Historic England

**SUMMARY OF WRITTEN REPRESENTATIONS**

**Highways England for an Order granting Development Consent for the A303  
Amesbury to Berwick Down**

**DEADLINE 2 SUBMISSION**

PROPOSED BORED TUNNEL - (WORK No. 1F)

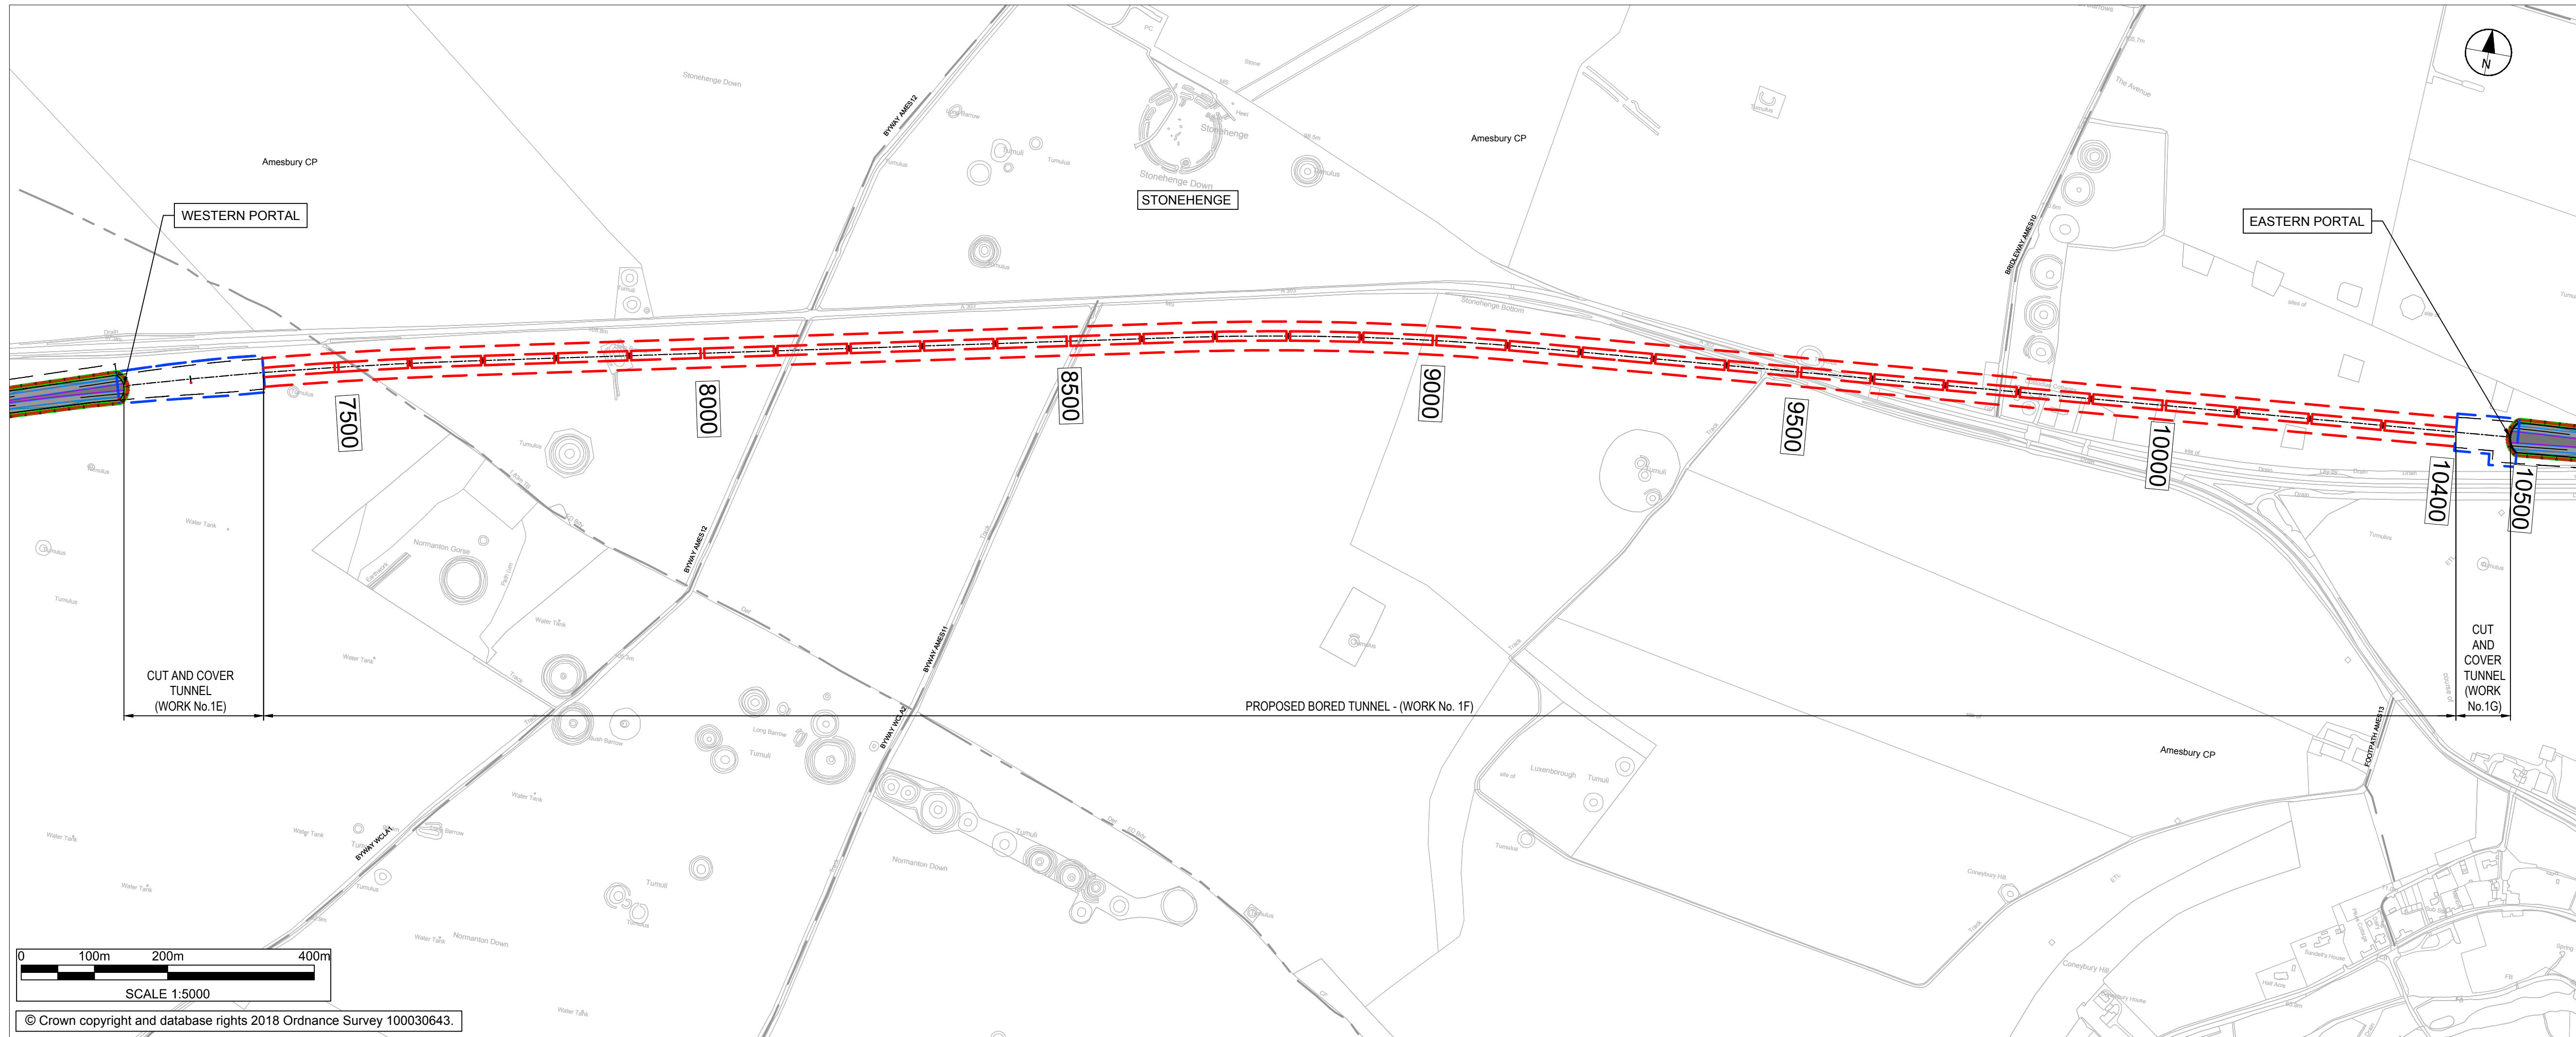
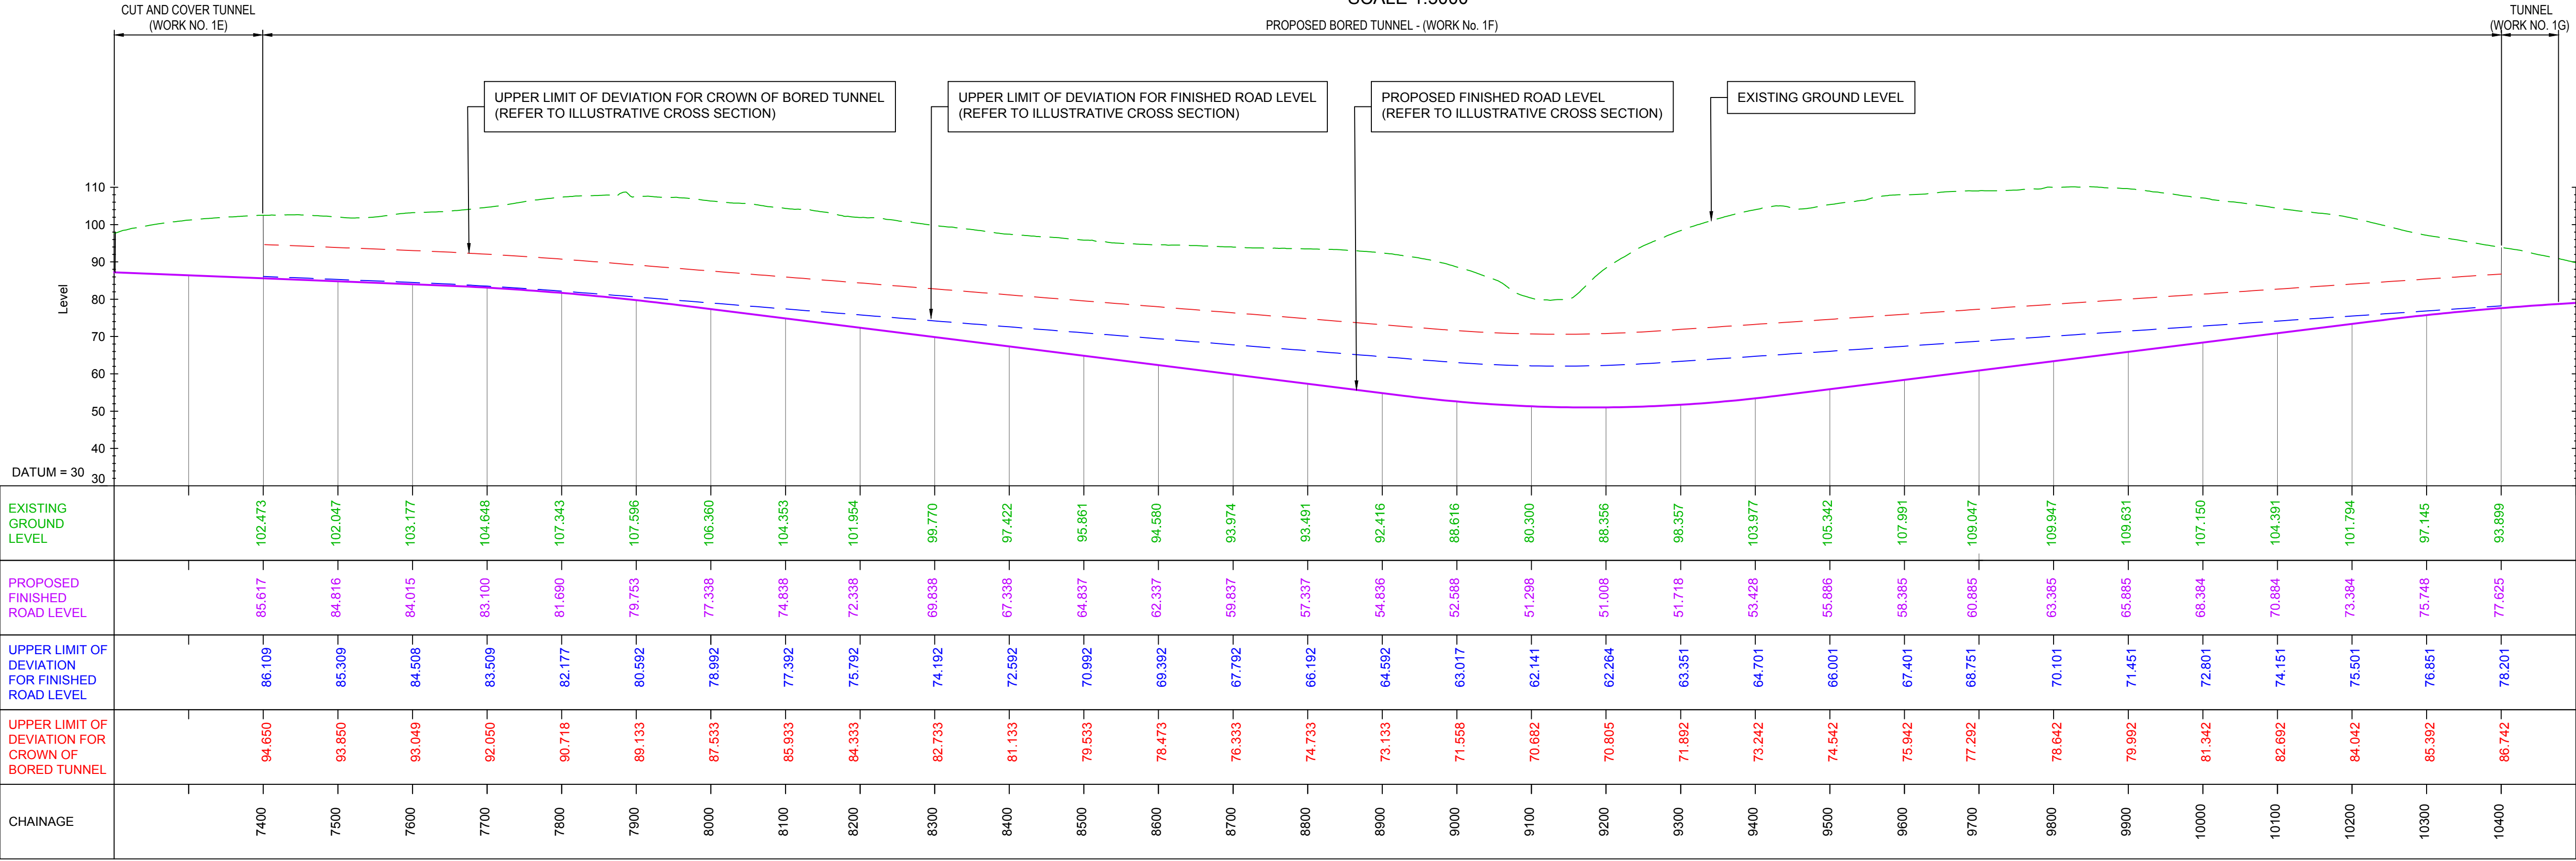
- (d) A greater degree of precision is needed in relation to the actual positioning of the tunnel portals given the sensitivity of the landscape. Historic England considers the limits of lateral deviation westwards in the first draft DCO of 200m for the western portal to be unjustified at this point.

- (k) Detail is needed (e.g. in relation to vertical limits of deviation for the tunnel), together with consideration of a parameters framework, to ensure that there is no restriction to potential future archaeological work above or below ground level but above the tunnel crown level identified in the first draft DCO. This would be contrary to Article 4 of the 1972 Convention and the policies of the SAAS WHS Management Plan.
